CITY OF ALBUQUERQUE

May 19, 2005

**Re: El Pueblo Apartments, 1015 Cardenas SE, Grading & Drainage Plan
Engineer's Stamp dated 5-9-05 (L18-D72)**

GRADING PLAN
SCALE: 1"=20'

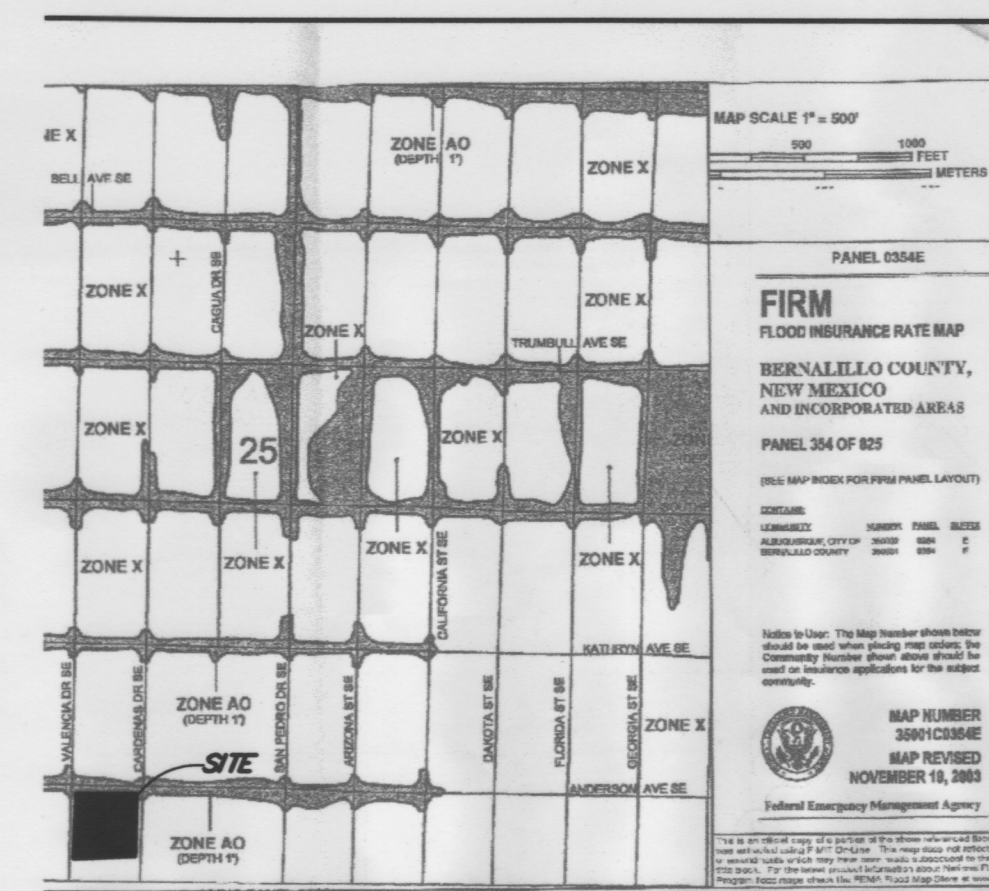
Based upon the information provided in your submittal dated 5-9-05, the above referenced plan is approved for Paving Permit. Please attach a copy of this approved plan to the construction sets prior to sign-off by Hydrology.
